Item No. **Report of the Interim Director of Planning, Regeneration & Public Realm**

Address 11 HARMONDSWORTH LANE HARMONDSWORTH

Development: Erection of a single storey side and rear extension following the demolition of existing garage and rear extension

LBH Ref Nos: **58750/APP/2022/2855**

**Title:**  
Proposed Flor plans.

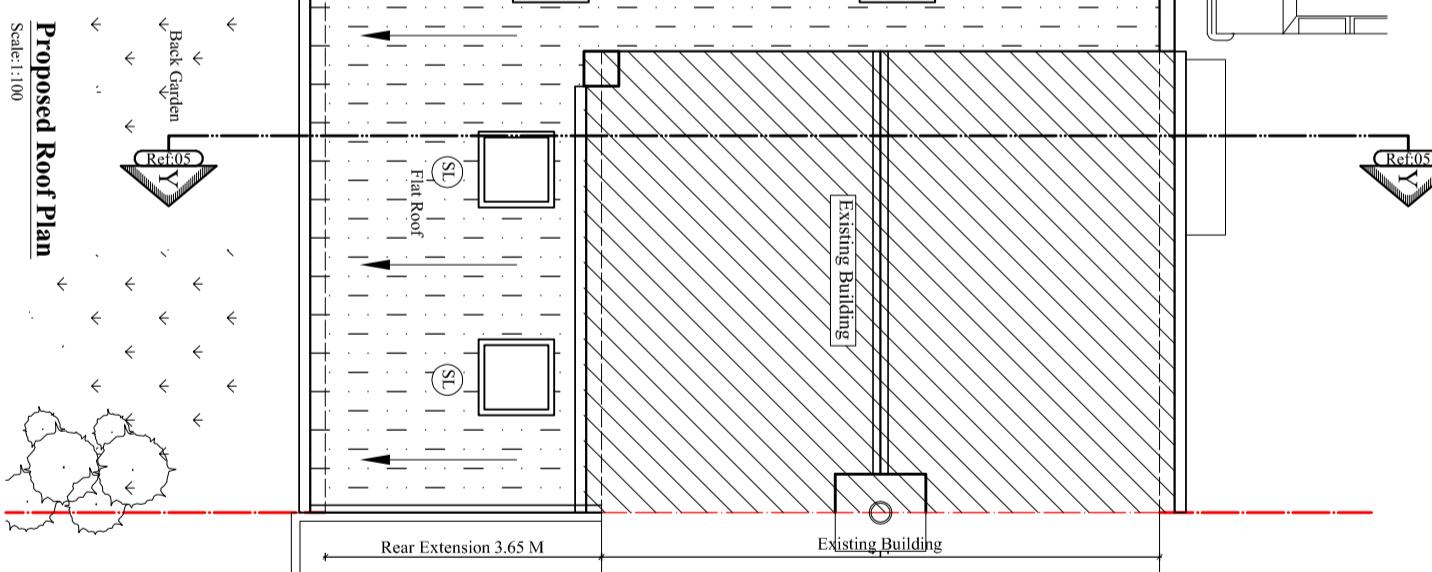
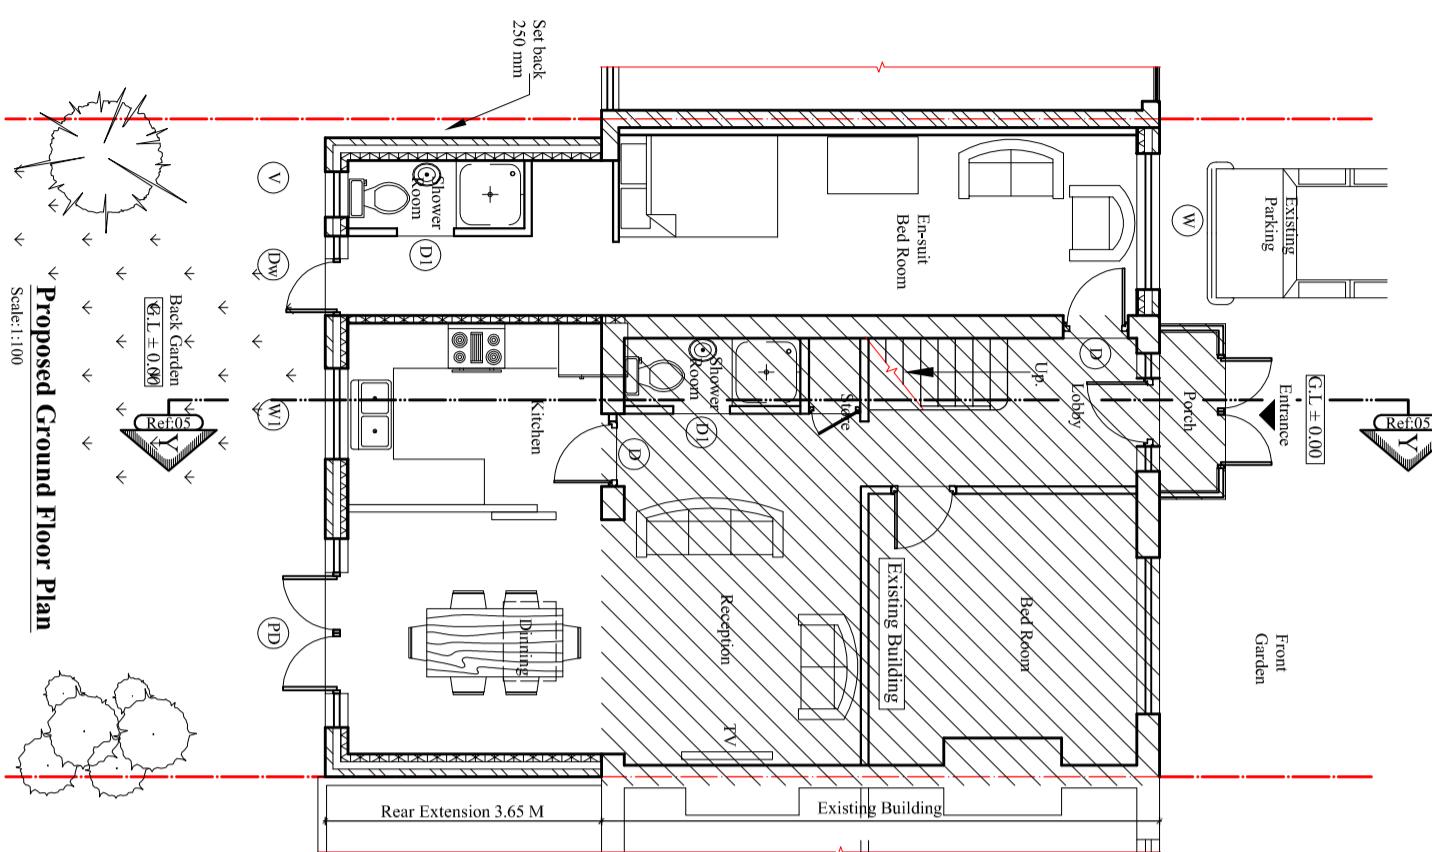
The proposed full width single storey rear extension would extend to a depth of 3.65m beyond the building line of the main dwellinghouse. The proposed single storey side extension extends along the full depth of the original dwellinghouse and extends to a depth of 3.65m beyond the rear building line of the original dwellinghouse resulting in a wrap around extension. The proposed side extension which will extend approximately 2.6m beyond the existing side elevation of the dwellinghouse to the side boundary. The wraparound extension will have a maximum flat roof height of 2.8m.

The rear extension exceeds the policy requirements by 0.5m, which would be minor and not result in a harmful impact to the host dwelling or the surrounding area. Also, it should be considered that the proposed extensions would be identical to that approved in application 58750/APP/2018/1552.

Title:
 Existing and Proposed Elevations.

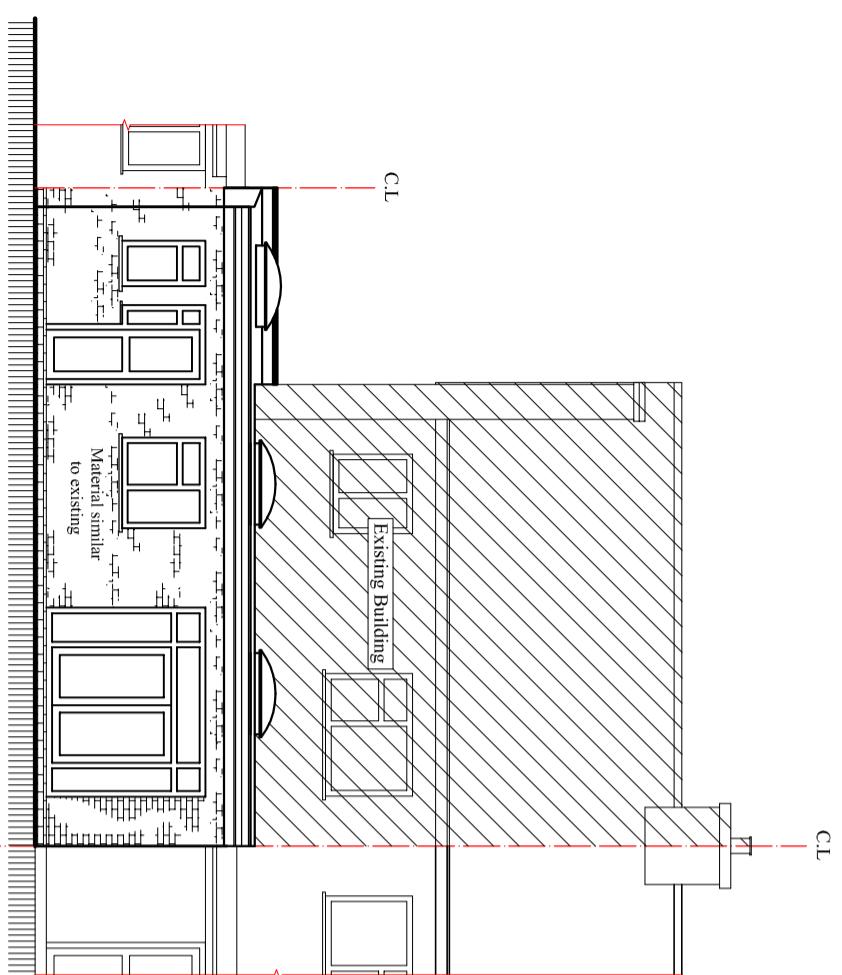
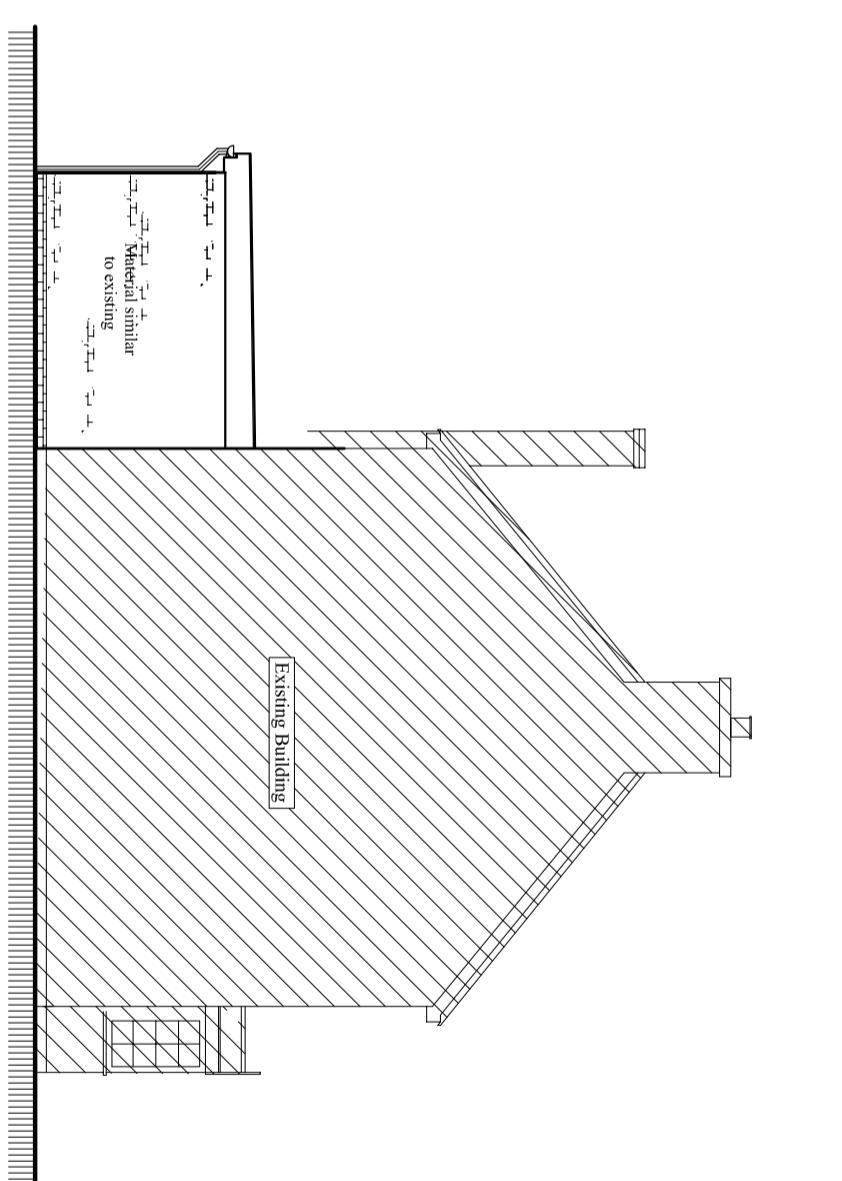
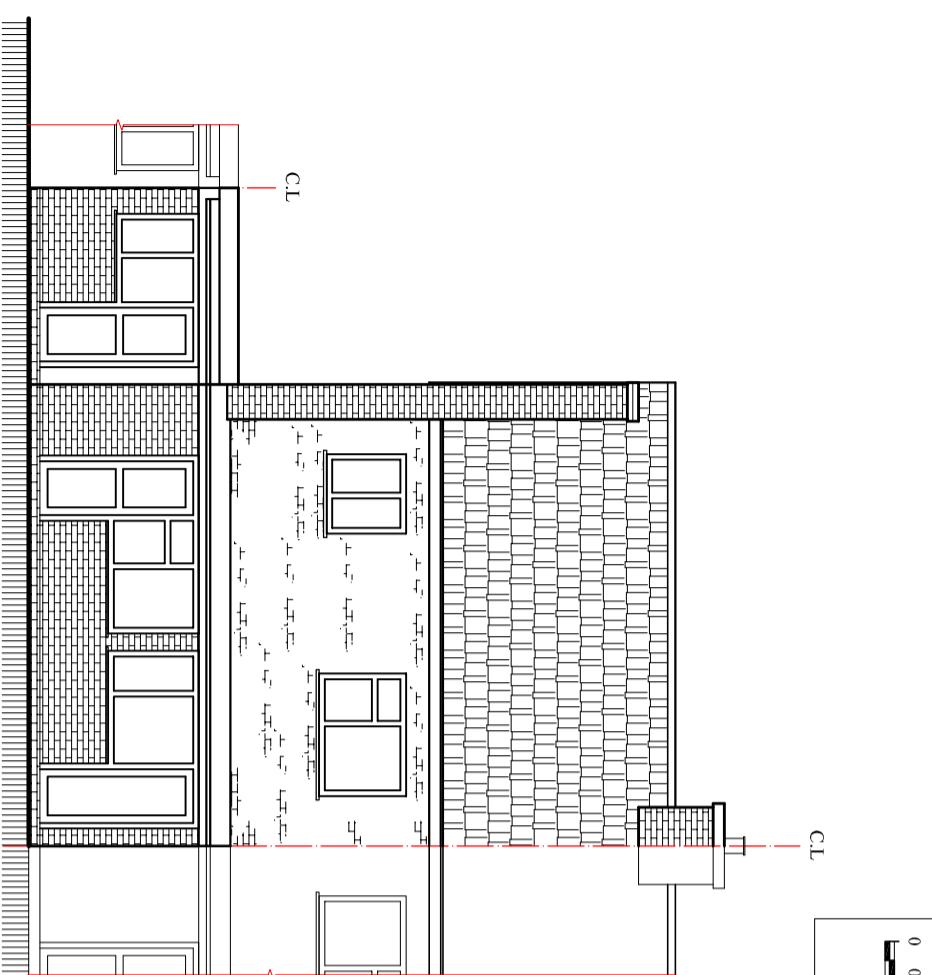
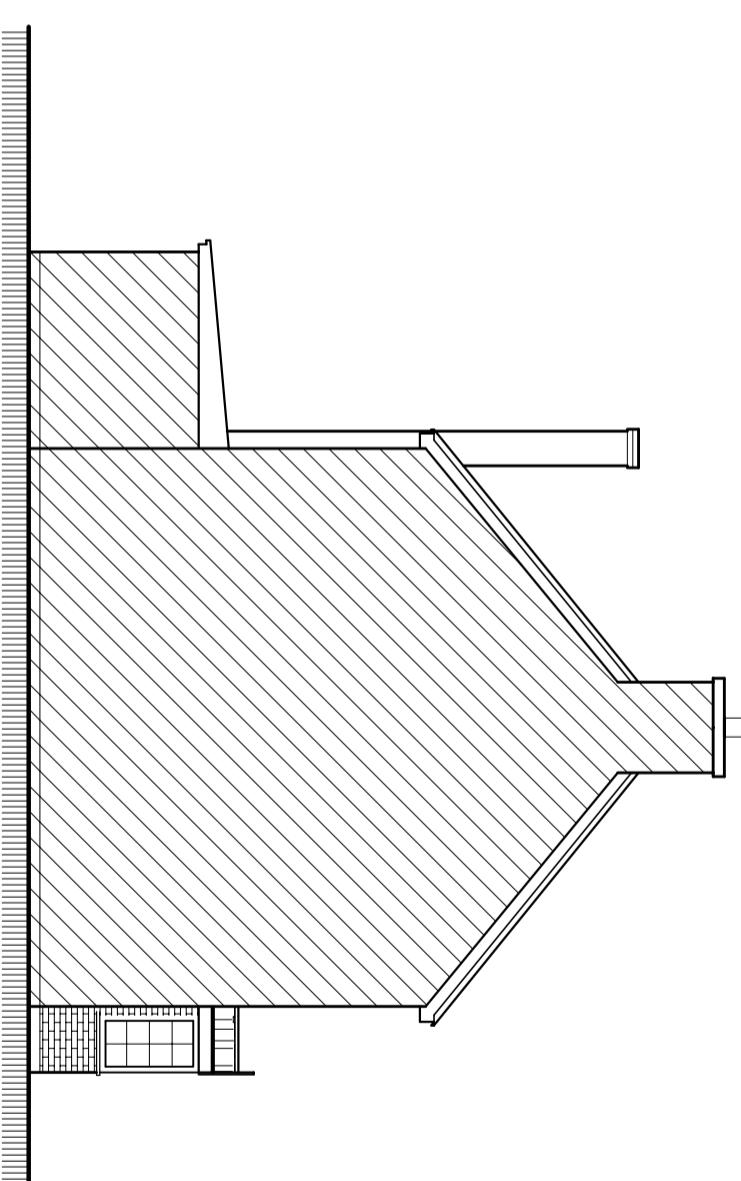
This neighbour has rear structure of 5.3 metres. The proposal would extend beyond the main rear building line of this neighbour by 3.65 metres, which would be almost in line with Policy DMHD 1. However, it would not exceed beyond the rear of the structure at this neighbour. As such, the side/rear extension would not have any harm on the amenity of this neighbour by way of overlooking, loss of light or outlook or by creating a sense of enclosure.

The proposal would exceed beyond the rear building line of this neighbour by 3.65 metres, which would be line with Policy DMHD. An additional 0.5m set back from the boundary has also been retained. This extension would not have an unduly detrimental impact on this neighbour.
